Rezoning Transportation Analysis

Petition Number: 2020-038

General Location Identifier: Tax ID 20143102

Date	Description
04-22-2020	First Review

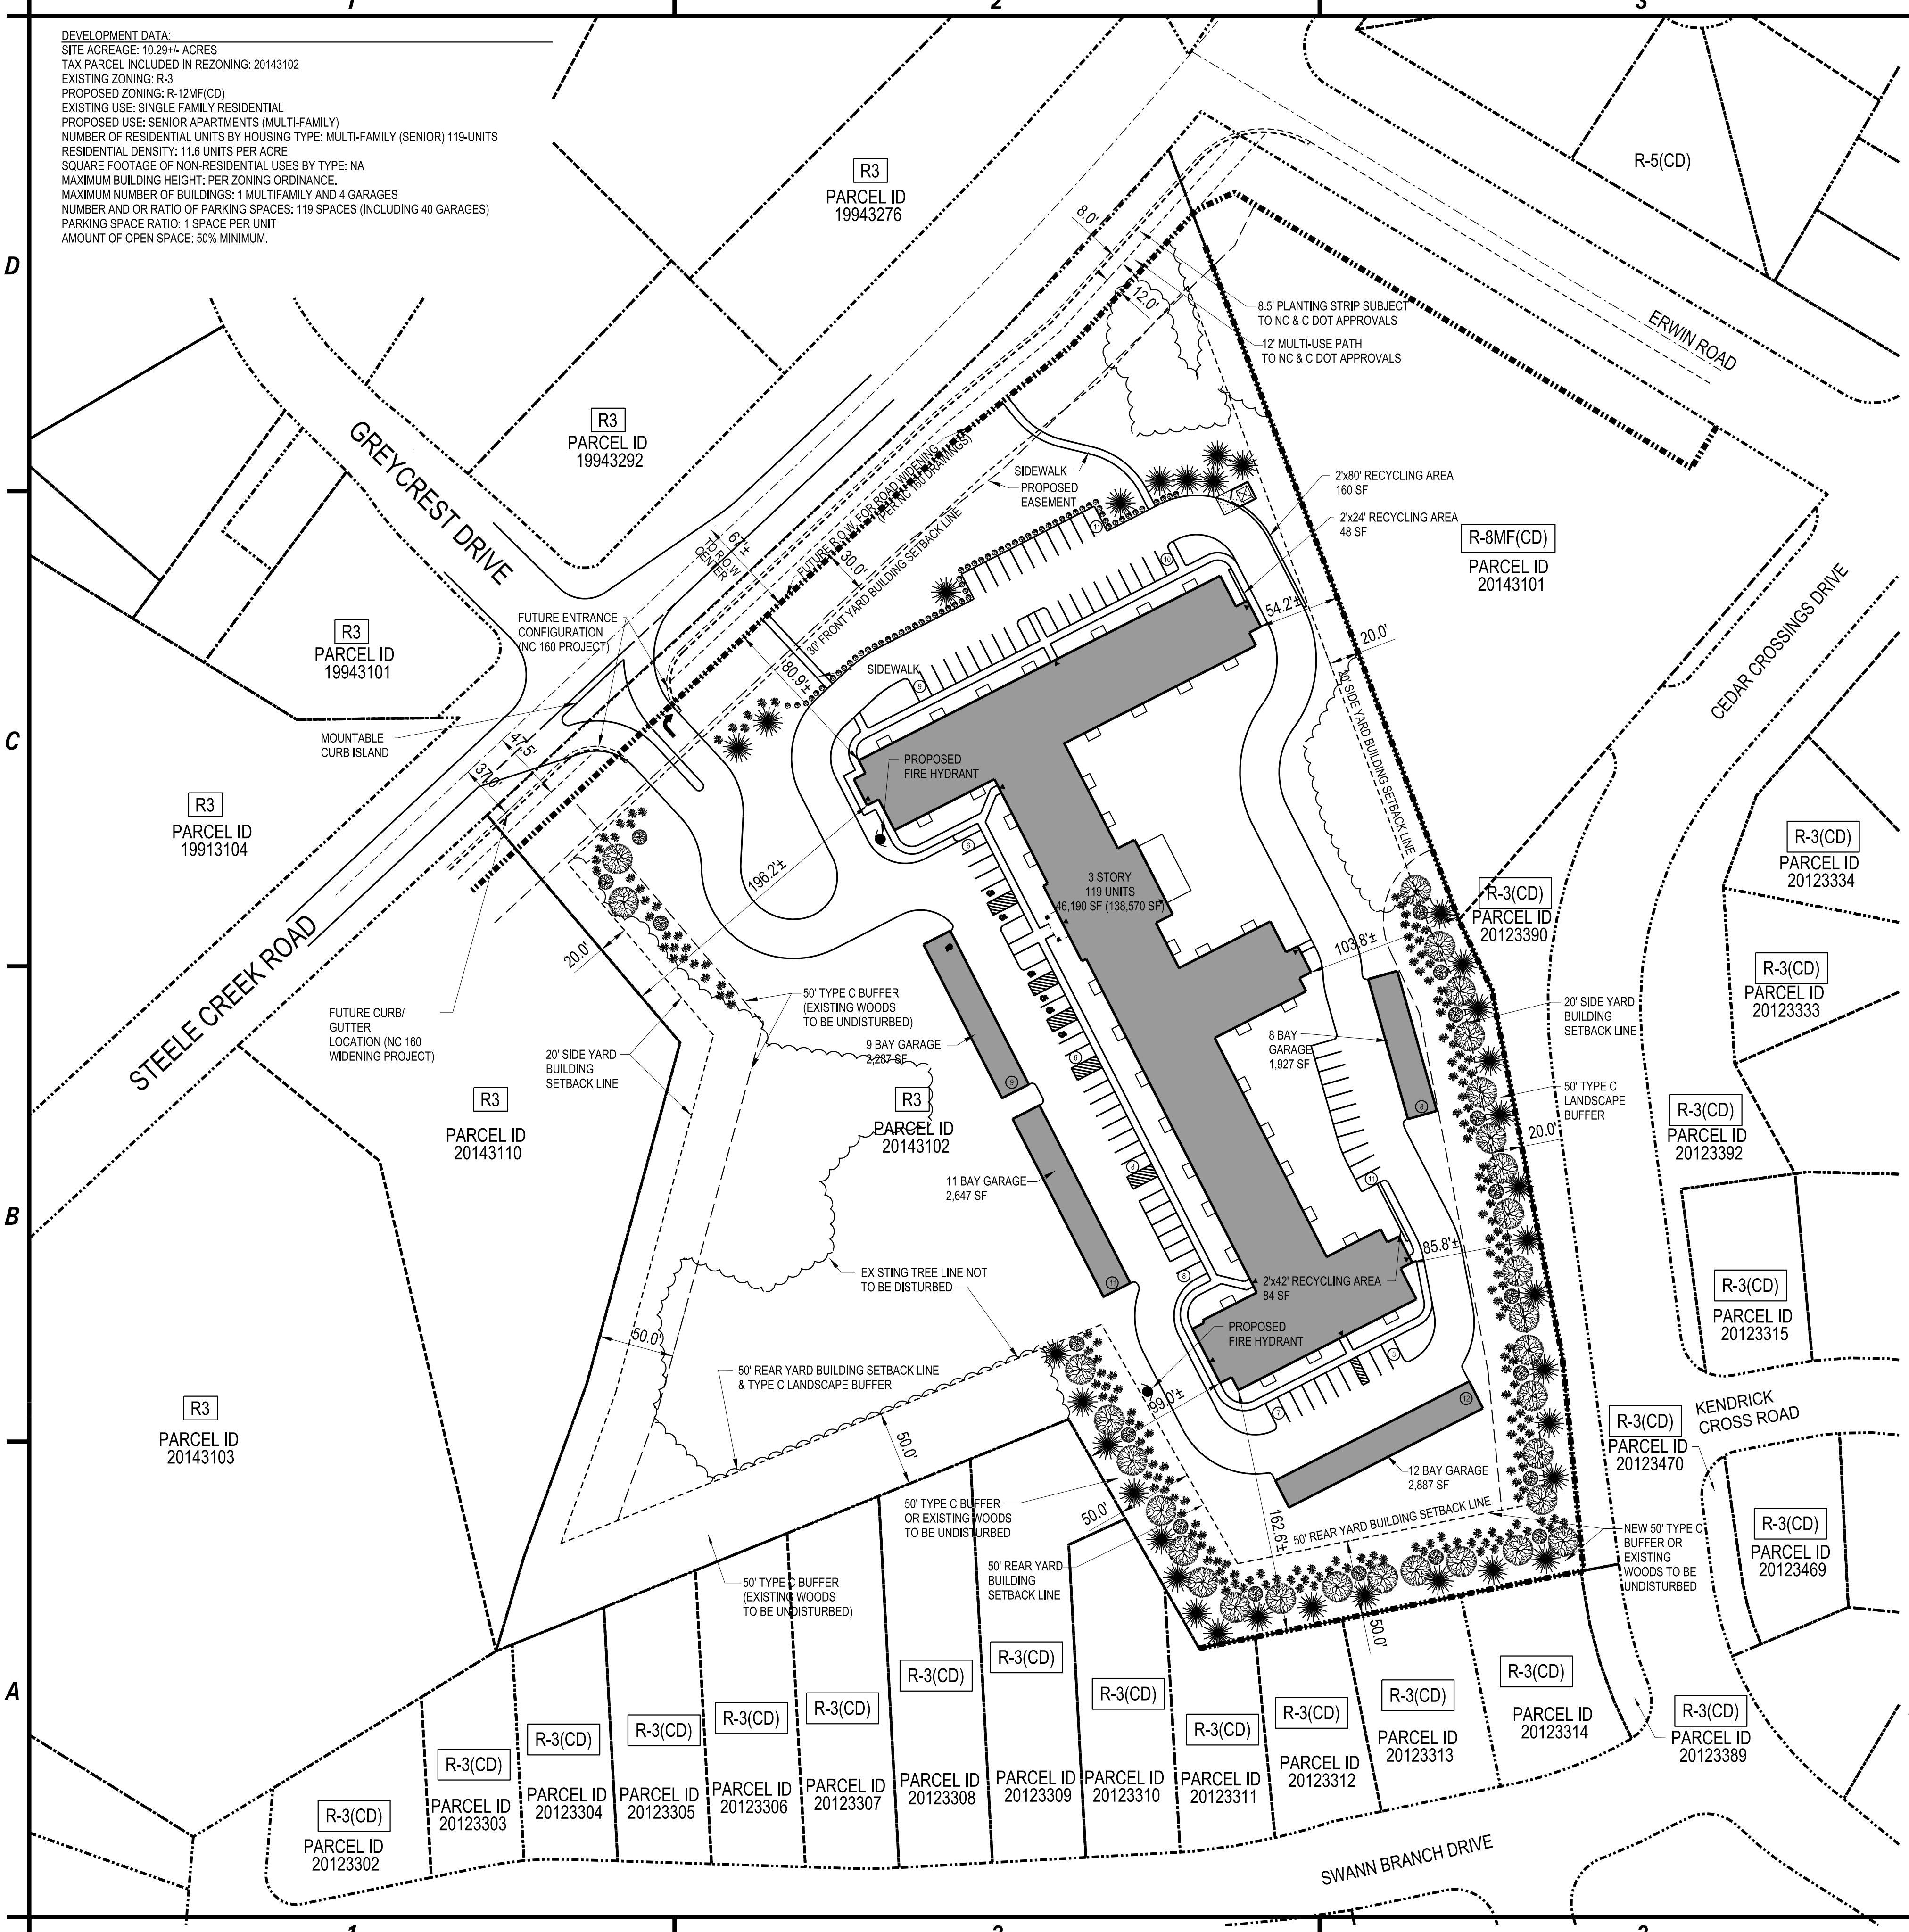
1. **Curblin**e The proposed zoning district has a setback measured from back of the existing or proposed future curblin)e.
 - a. **Steele Creek Road:** Location of curb and gutter needs to be shown on the plans based on the NCDOT TIP Project (U-5766) NC 160. The curb and gutter doesn't need to be constructed, but it does need to be shown on the plans.

The site plan should show the curb and gutter labeled and dimensioned from the centerline for each road.
2. **Traffic Study** A Traffic Impact Study is not necessary for the complete review of this petition due to the site generation more than 2500 daily trips. If the during the permitting process the site generates more than 2500 daily trips, then a traffic study will be required.

3. The petitioner should revise the site plan and conditional note(s) to commit to dedicate right-of-way from the road centerline for the NCDOT TIP Project (U-5766) NC 160. You can contact NCDOT for the exact location of the curb and gutter. The site plan should label and dimension the right-of-way from the road centerline.

4. The petitioner should revise the site plan and conditional note(s) to commit to a 100' right-turn lane into the NC 160 access point. It is an NCDOT requirement.

5. The petitioner should revise the site plan and conditional note(s) to commit to provide a 50-foot driveway stem from the future NC 160 right-of-way line.

6. The petitioner should revise the site plan and conditional note(s) to commit to construct a left-turn lane with 150' of storage and appropriate left-turn lane tapers based on the speed limit.

7. The petitioner should revise the site plan and conditional note(s) to show an exhibit showing full access with left-turn lane, and the future access on NC 160, based on the NCDOT NC 160 widening project. A conditional note should be added that the access will be changed based on the NCDOT project.

8. The petitioner should revise the site plan and conditional note(s) to commit to construct an 8-foot planting strip, and 6-foot sidewalk on Cedar Crossing Drive to meet the Subdivision ordinance. The site plan should label and dimension both items from the back of curb and gutter and road centerline.

9. The petitioner should revise the site plan and conditional note(s) to commit to construct an 8-foot planting strip, and 12-foot multi-use path on Steele Creek Road at its ultimate location. The site plan should label and dimension both items from the back of curb and gutter and road centerline

10. The petitioner should revise the site plan and conditional note(s) to include an additional access point to Cedar Crossing Drive, as the Subdivision ordinance require two access points for this type of development. The access should be located opposite of Kendrick Crossing Road.
